Re: Juan Tabo Hills Request for CLOMR Response to Comments (Project # 1005278)

Below, please see our response to your comments dated April 8, 2015 for our request for CLOMR for Juan Tabo Hills Estates.

PROJECT Twin Turbo Hills West
SUBJECT Section 3
BY _____ DATE _____
CHECKED _____ DATE _____
SHEET _____ OF _____

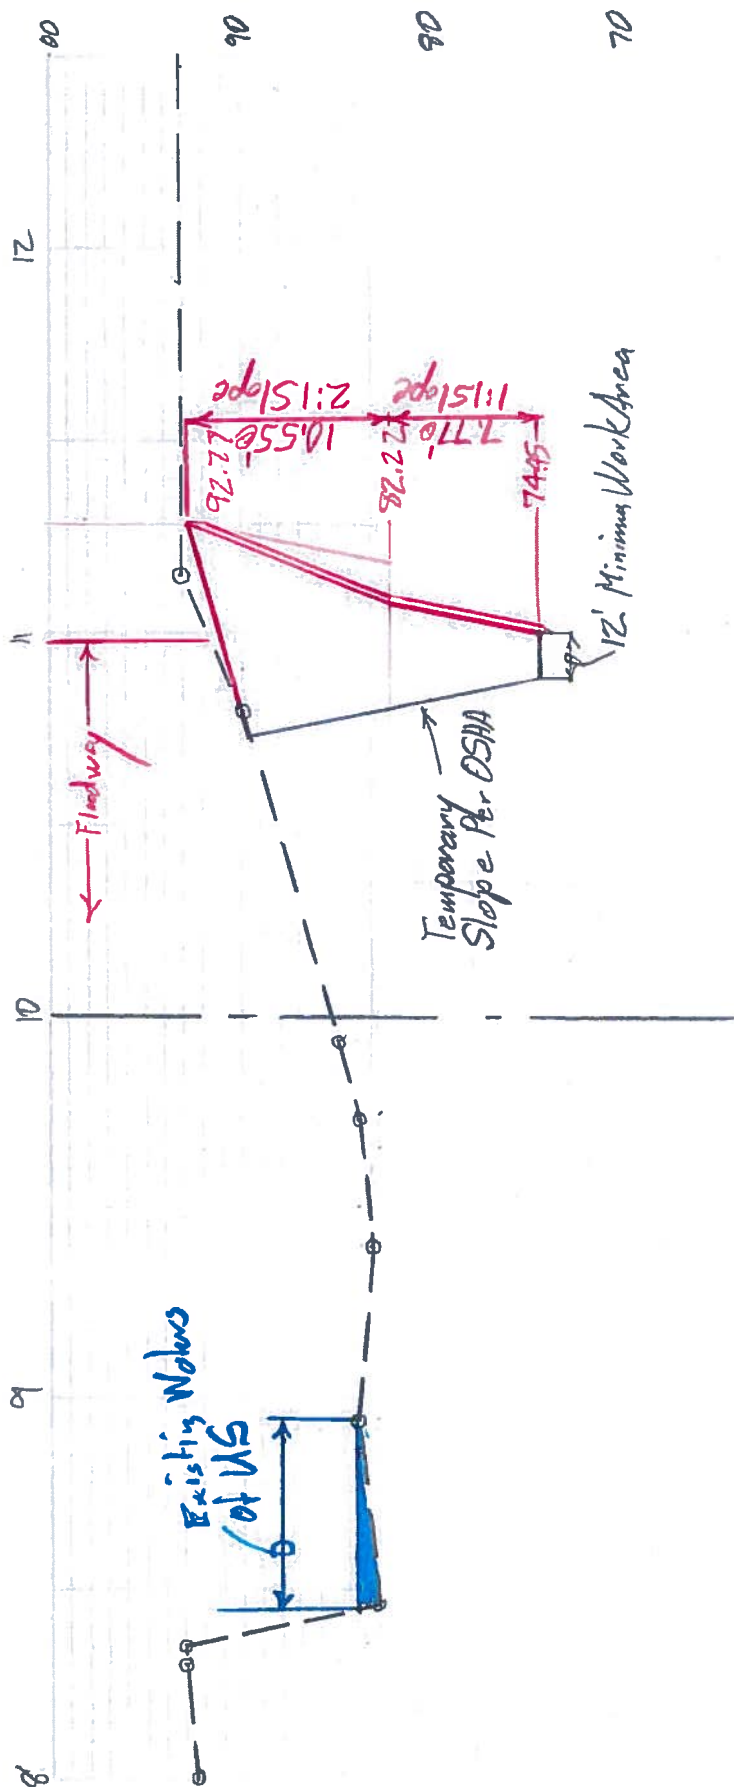
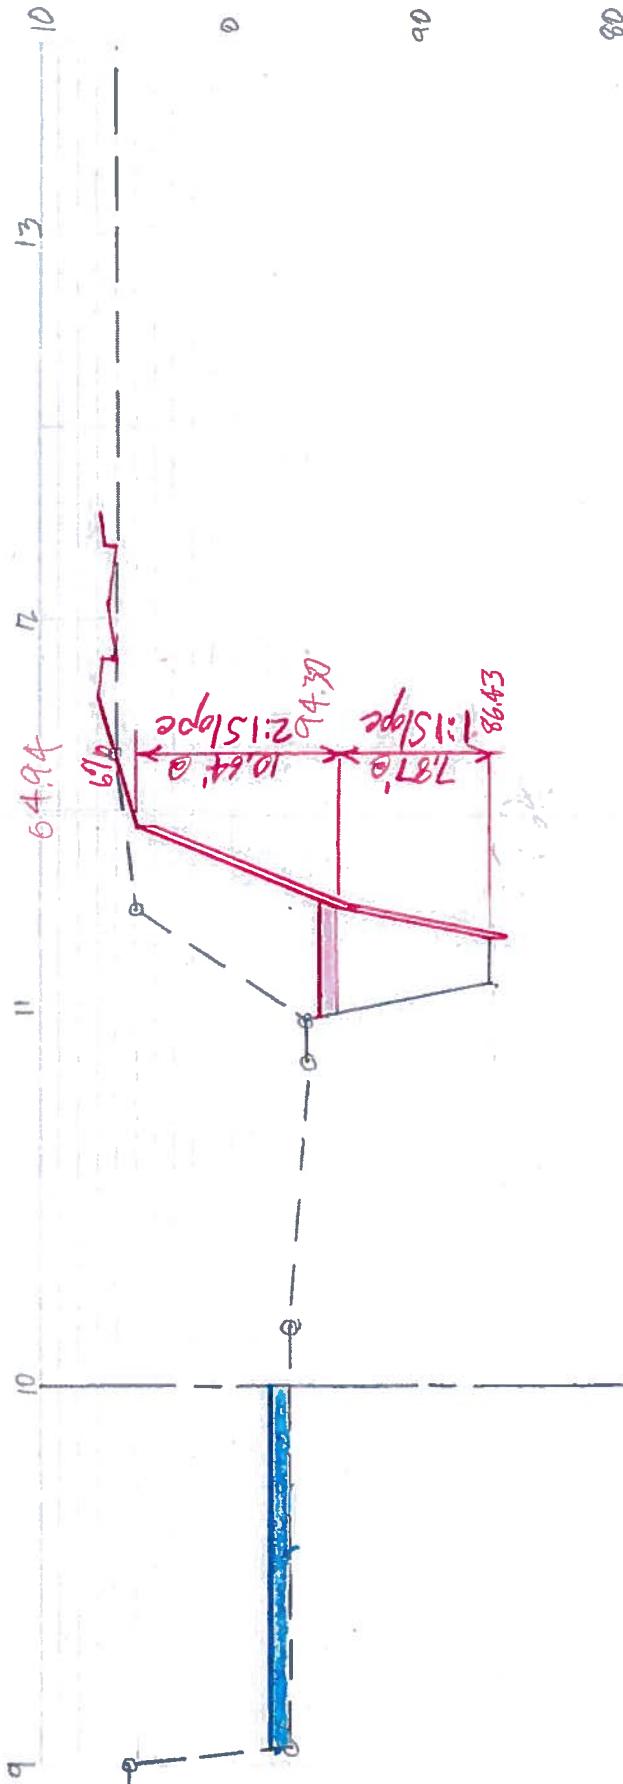
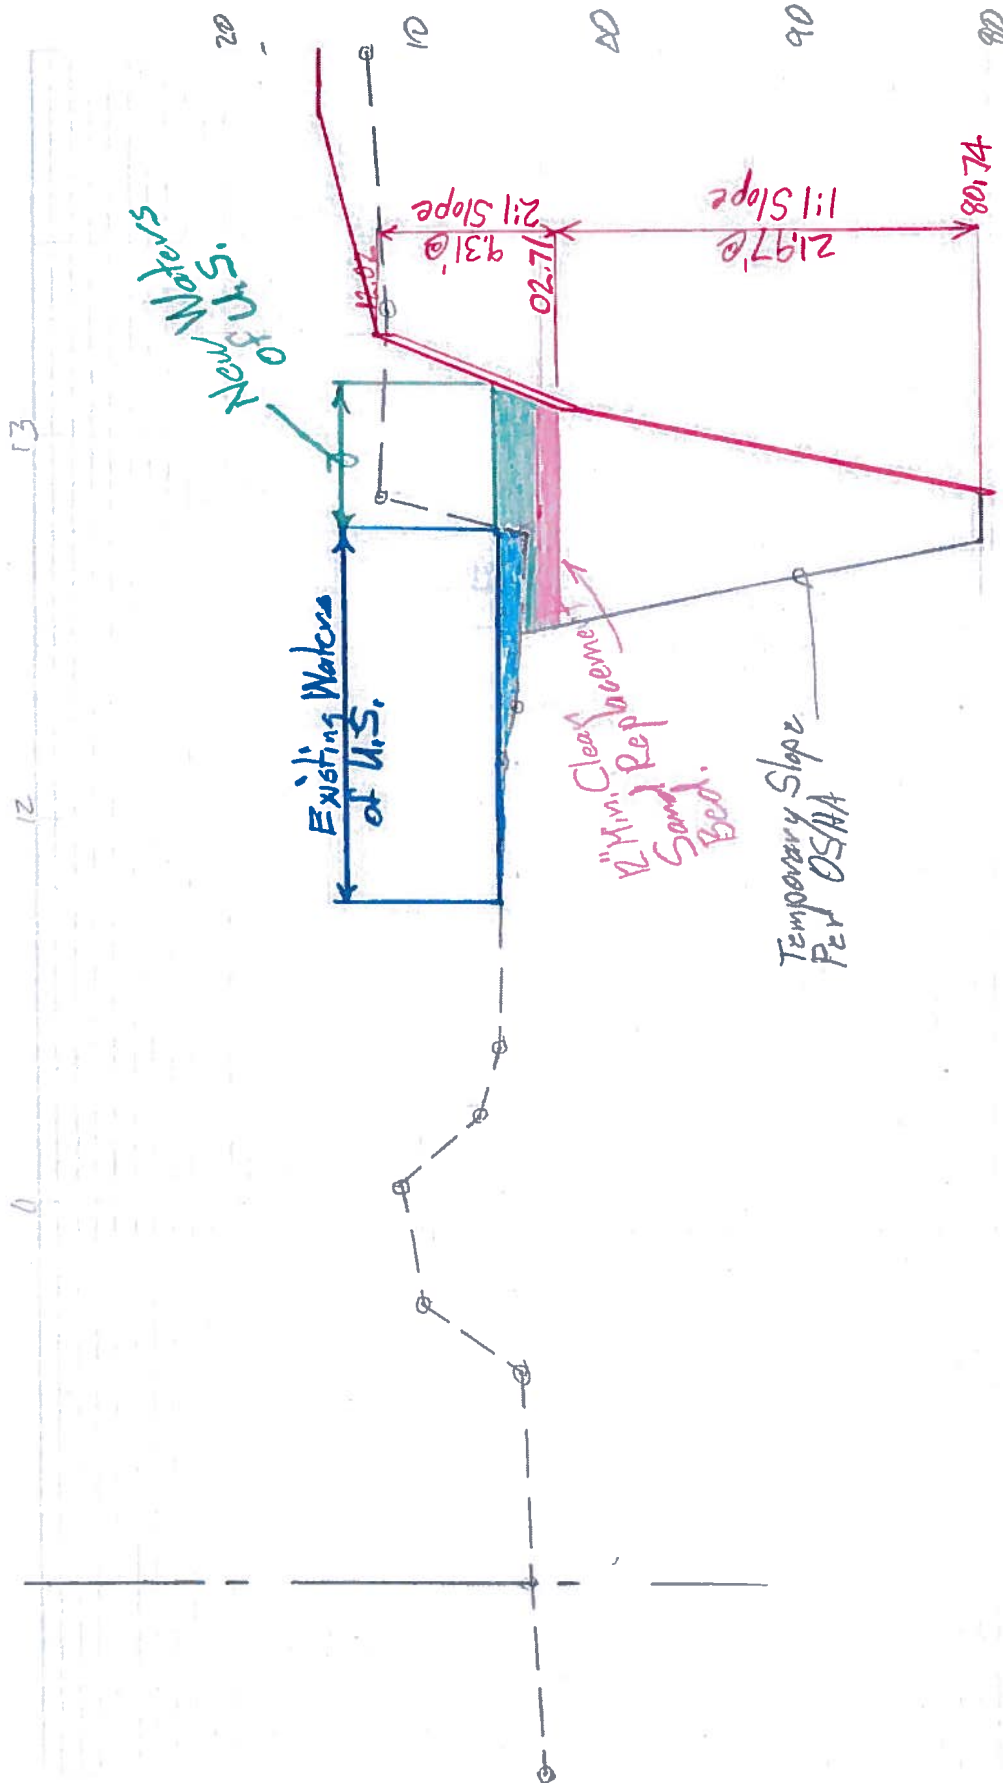
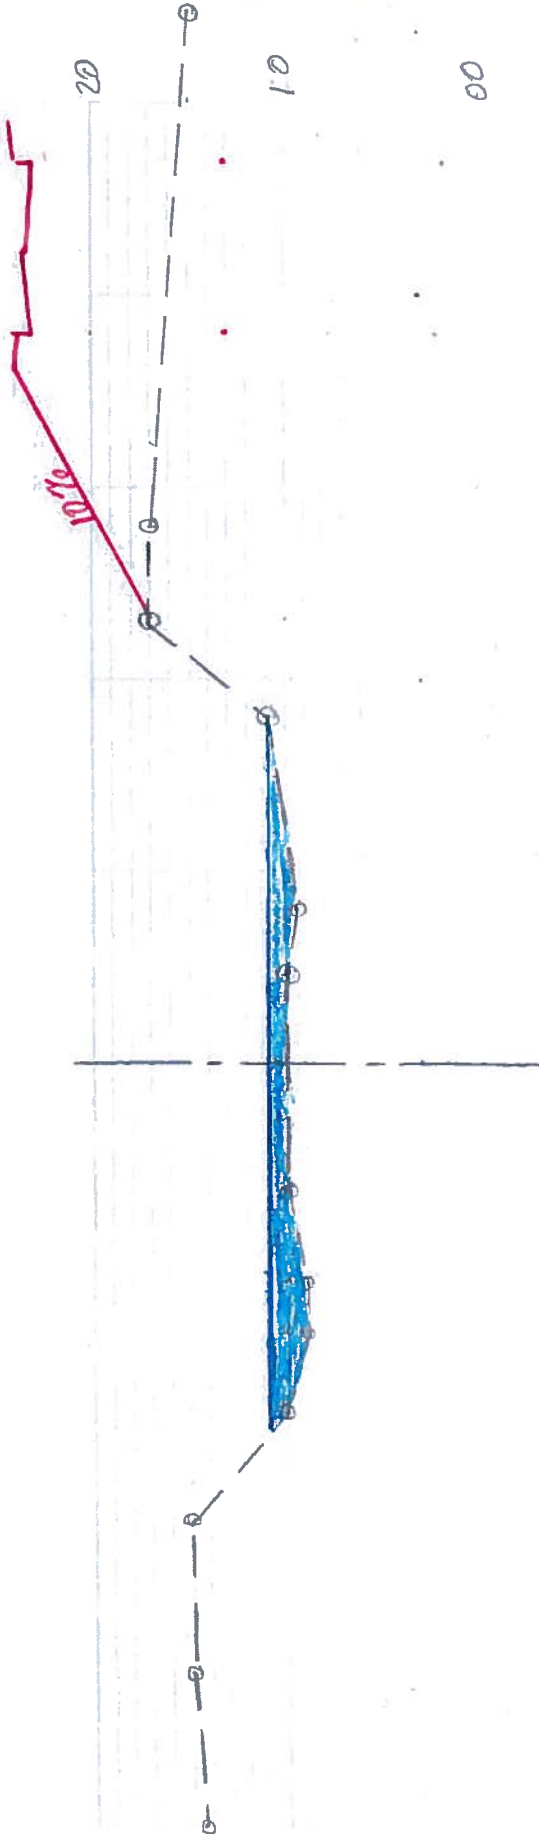
14. What is the purpose of the information in Sections 3 through 6? If they are cross section of arroyo improvements, they should be drawn to scale and show existing and proposed grades. The "cross sections" tab includes scale cross sections at each HEC-RAS section location showing both existing and proposed finished grades as well as temporary grades that will exist during construction and the subsurface extents of the Bank Protection as necessary to provide Scour Protection according to the equations and calculating shown on the Bank Protection Profile. That is more information than FEMA cares about but it is design considerations that AMAFCA is interested in.
